**Reserved Matters Application pursuant to Outline Planning Permission 14/02121/OUT for the erection of 123 dwellings (including 37 affordable dwellings), parking, landscaping and other associated infrastructure including the part discharge of Conditions 12 (Building for Life 12), 13 (Future Climate Risks Statement), 14 (Noise Assessment, 16 (Means of Vehicular Access), 17 (Means of Pedestrian / Cycle Links), 18 (Travel Plan) and 19 (Detailed Surface Water Drainage Scheme) at Phase 2A, Himley Village, Bicester**

Further to ongoing discussions with yourself and other Statutory Consultees I am submitting a revised scheme pursuant to Reserved Matters application 23/01586/REM for Phase 2A, Himley Village, Bicester. We have reviewed the consultation responses received on the application to date and have the following responses set out below.

AS:
90-91, 92-93,
94-95, 96-97
OPP:

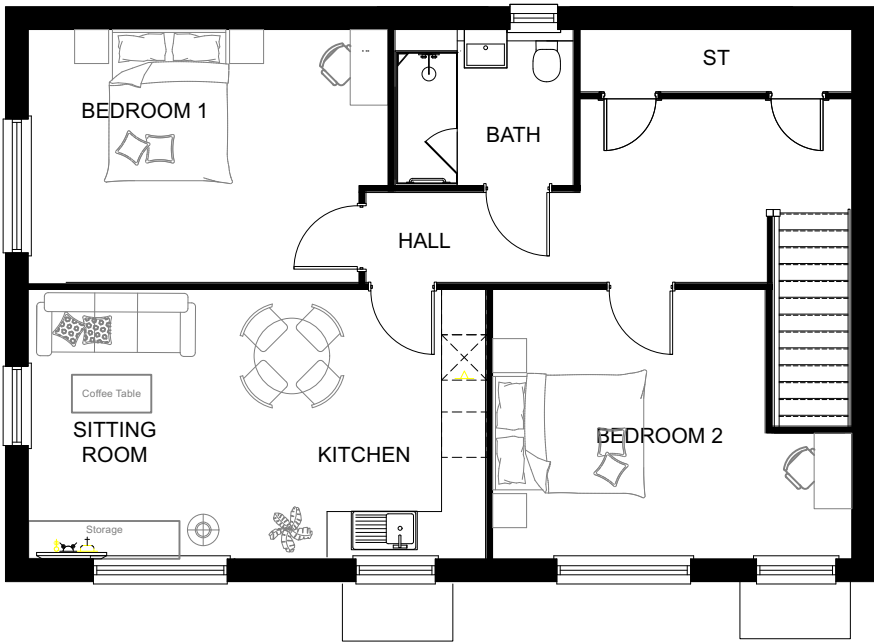
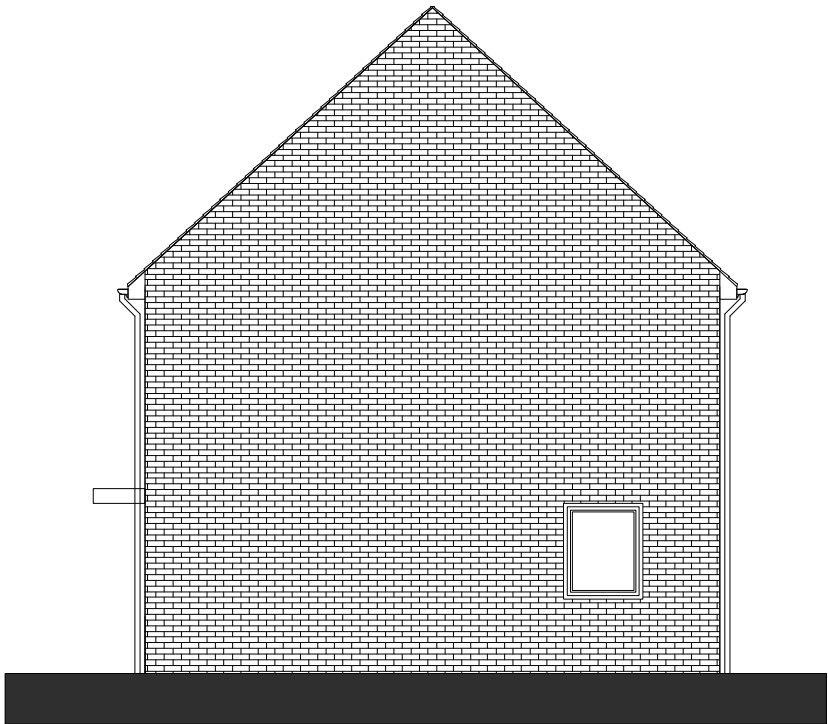
- One of the 1-bed maisonettes (plot 90-93) appears to be half s/o and half rented, which RPs don't favour. Same with plot 105-106 where there's a 2b3p s/o flat with a 2b4p rented flat above.
- Could Cala deliver 2x 1-bed or 2x 2-bed flats as s/o together? And then with the other plot, instead of 2x 1-bed or 2-bed rented flats we can have a 4-bed house. It means 1 less unit of affordable housing overall but it works with their plan and the 30% housing required equates to 36.9 rather than 70.
- This may be a suitable compromise and the above means 1x 4-bed house in place of 2x flats and also fixes the issue of mixing rented with s/o whilst retaining the applicant's preferred layout.

The original Reserved Matters submission for Phase 2A included 2 blocks of Affordable Rent apartments comprising of 6 one bed and 9 two bed apartments. The current need in Cherwell District is for 1 and 2 bed maisonettes instead of apartments and so the revised layout for Phase 2A has removed the apartments and replaced them with maisonettes.

The above table and a draft layout were submitted to Ewan on 3<sup>rd</sup> June 2024 and it was confirmed on 5<sup>th</sup> June 2024 that following the swapping of apartments for maisonettes and increasing the number of 3 and 4 bed Affordable Rented homes, Strategic Housing would support the revised mix in full. It has also been agreed that apartments have been deemed appropriate on future phases at Himley Village. The email chain is appended to this letter for clarity.

HIMLEY VILLAGE, BICESTER – PHASE 2A – SINGLE GARAGE

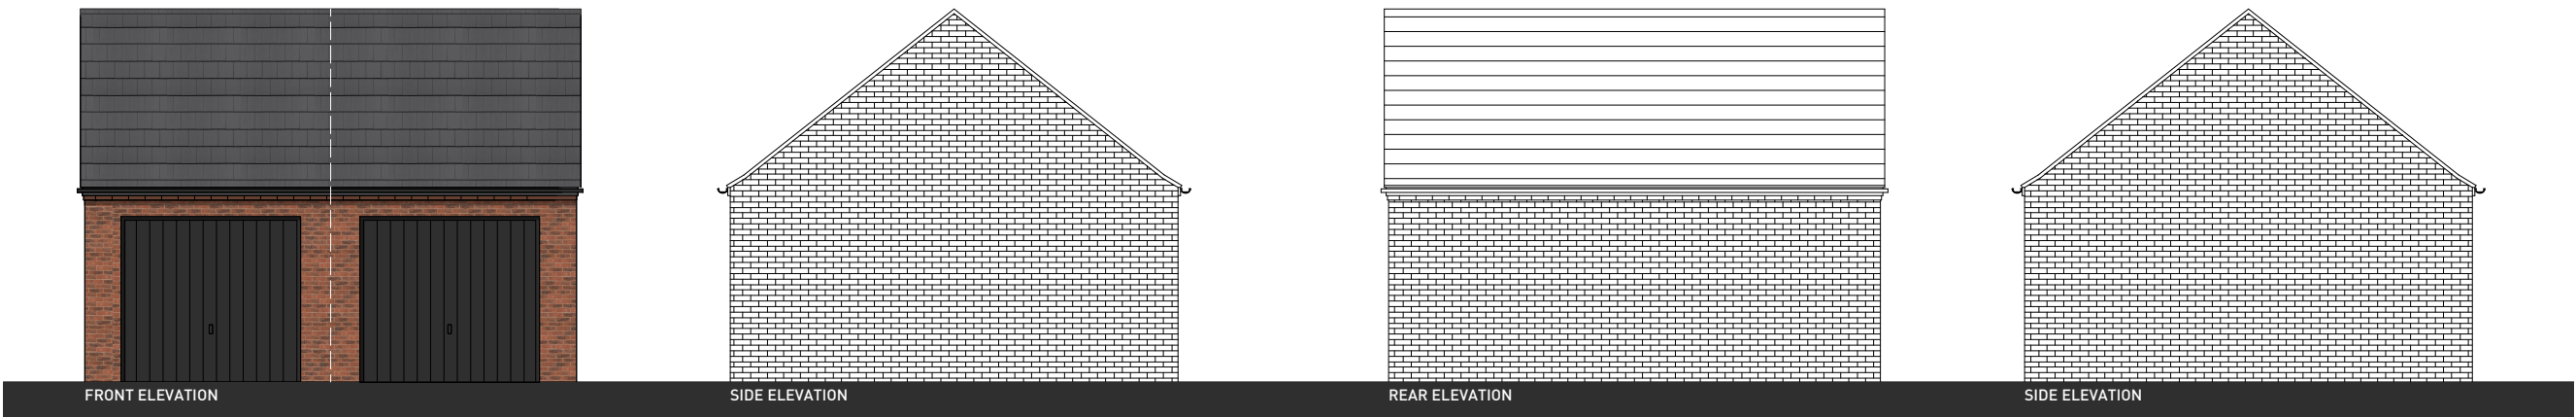
1. *Amount of parking exceeds Oxfordshire Parking Standards.*

The number of parking spaces has been amended in order to accord with Oxfordshire's Parking Standards. The size of garages has been reduced so that they don't count as a parking space and the number of parking spaces for each dwelling accords with Oxfordshire's Parking Standards.
